Ref Topic Construction Phase, (O) - Operation Phase	Natural England commentary and advice on the further information required to enable assessment Natural England comment on the mechanism for securing mitigation/compensation measures in the DCO/deemed marine licence	Comment addressed in signposting docs received 12.06.23?	Where in signposting docs?	Do NE consider that this point is now fully addressed / resolved?		NE Additional Advice (sent to ABP 30 June 2023) Comments made by ABP during meeting 03 July 2023	Additional note(s) from ABP 10 July 2023	NE Additional Advice (sent to ABP 03 August 2023)	Natural England position at Deadline 6 (13 November 2023). Documents reviewed: updated Habitat Regulations Assessment Report (HRAr) [REP5-020] / IERRT Written Representation Signposting Document (Sent directly to NE on 06 October 2023)	RAG rating for specific RAG rating for ke
	General comments and	Natural England recommends that the assessment of potential air quality impacts from construction and operational phase traffic is undertaken in-line with our guidance note NEA001. The assessment should clearly define the plans and/or projects that					We assume that the mudflat habitat referr

**CONSTRUCTION ACTIVITY ASSOCIATED  
WITH CAPITAL DREDGING AND  
POTENTIAL DISTURBANCE ZONE BUFFER**

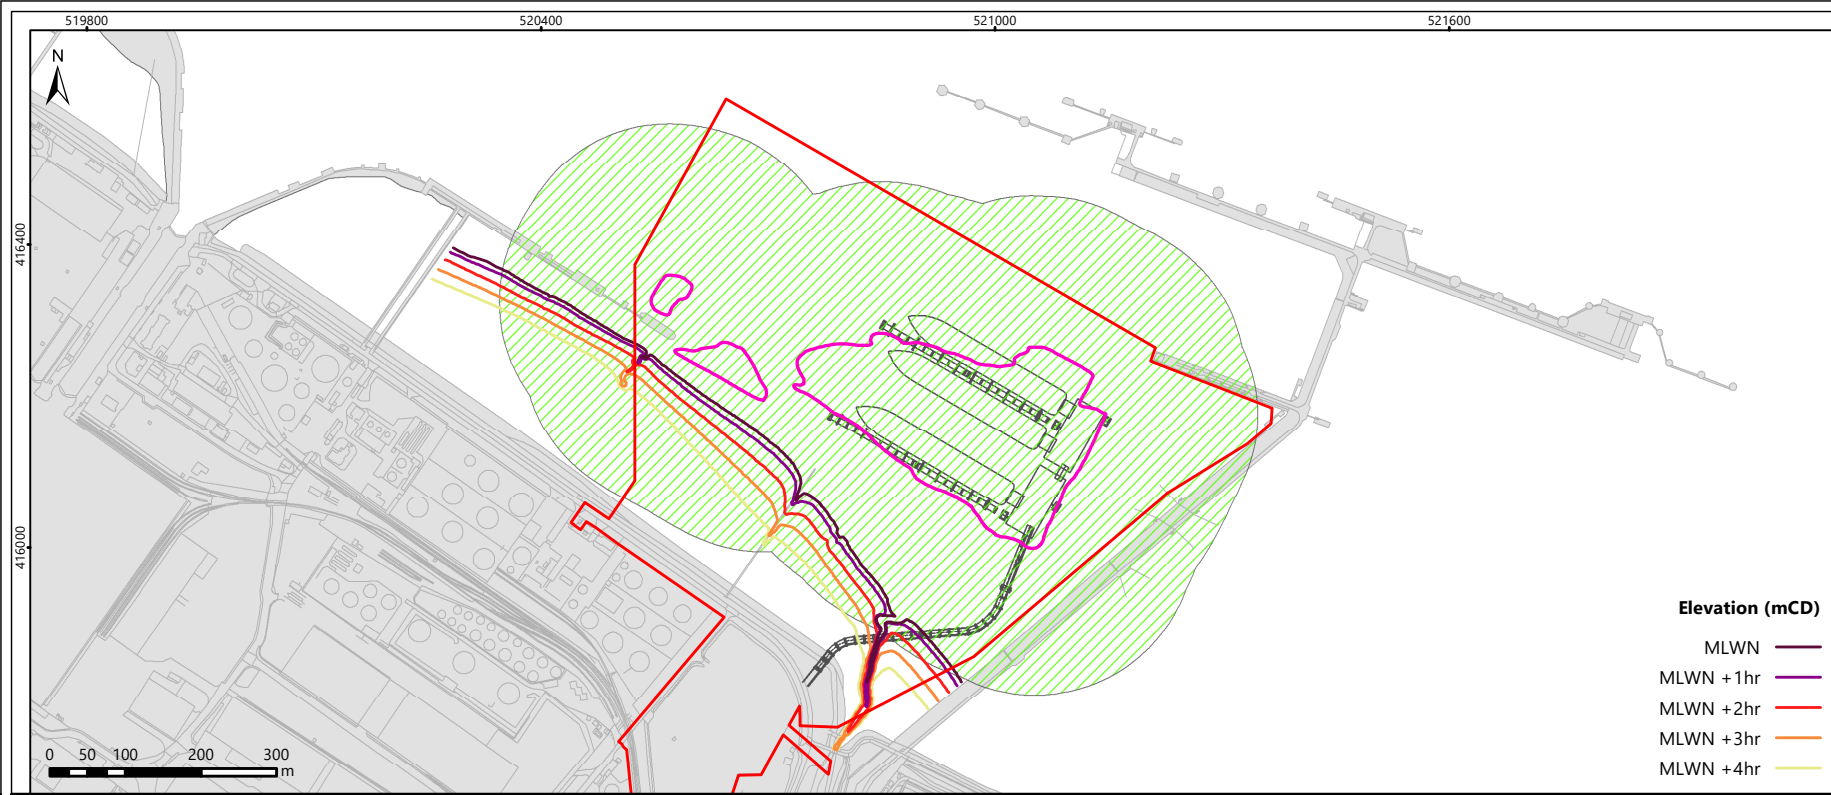
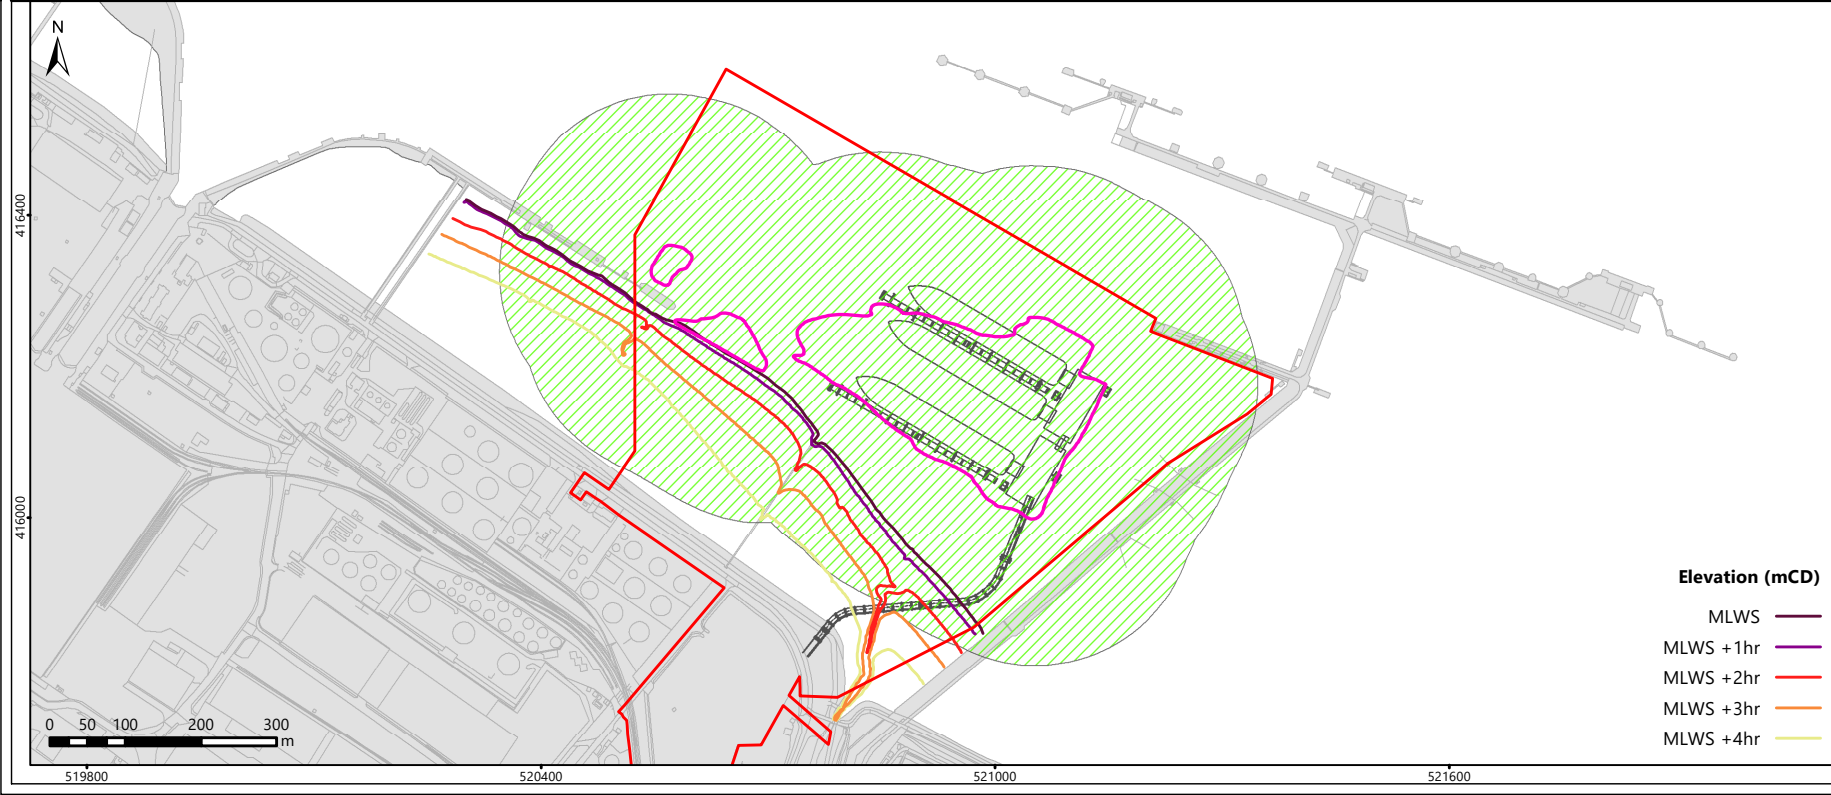
International designated sites • Eumber Estuary SPA • Umber Estuary Ramsar • Estuary Ramsar	Section 4.10.29 states that birds that are disturbed from intertidal areas by construction works can us other areas beyond 200m of works (Figure 9.10 of the ES), or could feed at night around the construction zone (once work has stopped). If. birds are already feeding at night, this does not represent an additional feeding period to make up for the effects of construction disturbance. Further assessment is required around the potential energetic costs to birds as a result of this level of	N/a: Further information required	Yes	Bird Disturbance - Key Issue 7 - Point 8)	N/a	Awaiting advice from NE Specialists. Advice to follow	Awaiting advice from NE Specialists. Advice to follow			Further assessment will be required around this element. With regard to energy budgets it is important to note that one of the key species we are concerned with is black-tailed godwit, which is on the edge of its range around the humber and can be particularly tight on its energy budget, especially if food is scarce and weather is harsh. Further advice from ornithologist on signposting document which refers to Collop et al. (2016): The Collop et al. (2016) paper does not consider one of the key species of concern which would be black-tailed godwit. Alves et al. (2013) found that the black-tailed godwit population that winters on the East coast of England are energetically stressed with the energy demand in January-March exceeding the energy input in their studies. Godwits wintering in this location must feed during both low tides. References: C. M. Beale and P. Monaghan. 2004. Behavioural responses to human disturbance: a matter of choice?, Animal Behaviour, Volume 68, Issue 5. WeBS Low Tide Count Data suggests that black-tailed godwit are more restricted than other species in where they will feed at low tide. Alkborough Flats, Reads Island Flats and the Sectors from Halton Marshes to Pyewipe (including Immingham) appear to be of key	We welcome the additional information provided in Table 29, however, it is the view of our ornithologists that black tailed godwits are at their energetic northern limit on the Humber on the east coast in the winter. The species will occur on passage on coastlines further north (and possibly in small numbers over the winter), but in terms of large numbers of overwintering black tailed godwits, the Humber Estuary is the northern limit on the east coast. It is therfore very important that this species can use foraging areas on the Humber at both low tides, particularly during the coldest months. This therefore remains an ongoing matter.	Amher	Amber
